CITY OF ALBUQUERQUE

Re: Horizon Academy West
Grading and Drainage Plan
Engineer's Stamp dated: 1-31-13, (G10/D029B)

GRADING AND DRAINAGE PLAN

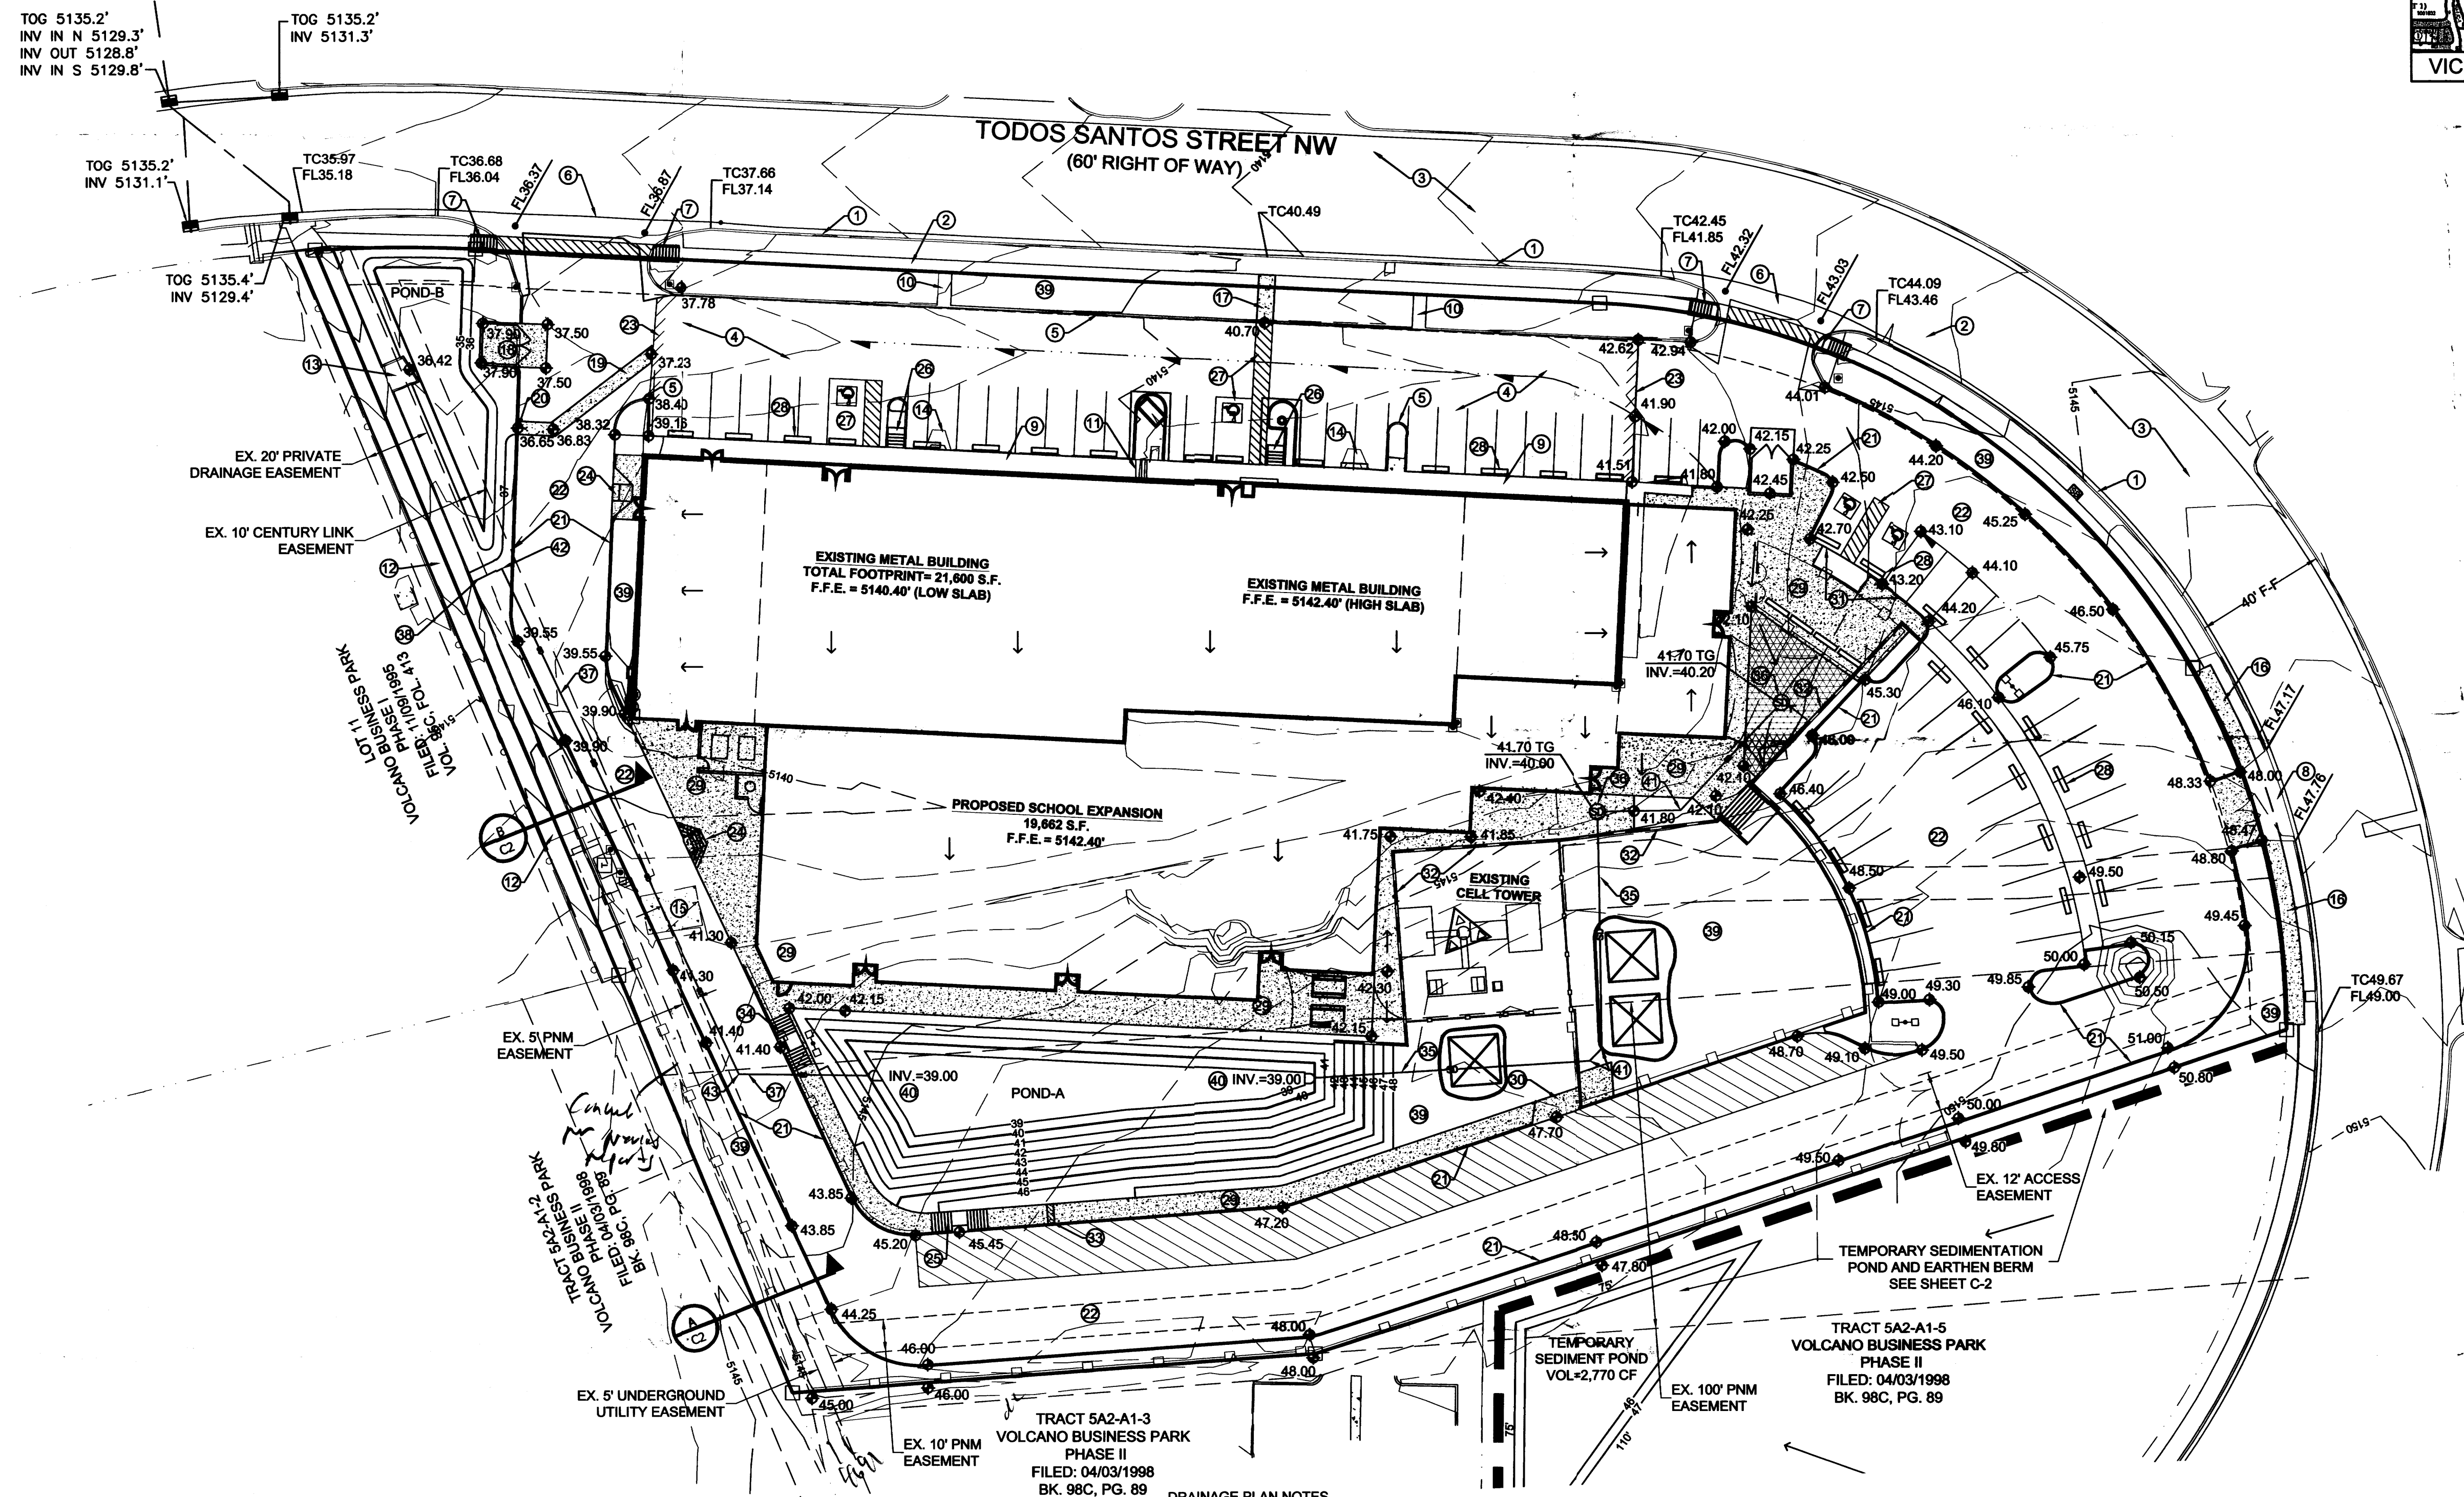
Based upon the information provided in your submittal received 1/31/13, the above referenced plan is approved for Building Permit. Hydrology is requesting that proposed landscape areas be depressed to retain/infiltrate the rain that falls on them.

This project requires a National Pollutant Discharge Elimination System (NPDES) permit for storm water discharge and a Topsoil Disturbance Permit since it is disturbing $\frac{3}{4}$ of an acre or more. Prior to Certificate of Occupancy release, Engineer Certification per the DPM checklist will be required. Also, on the 6" line leaving pond A, show spot elevations at the 90 degree turn and at the invert in the channel.
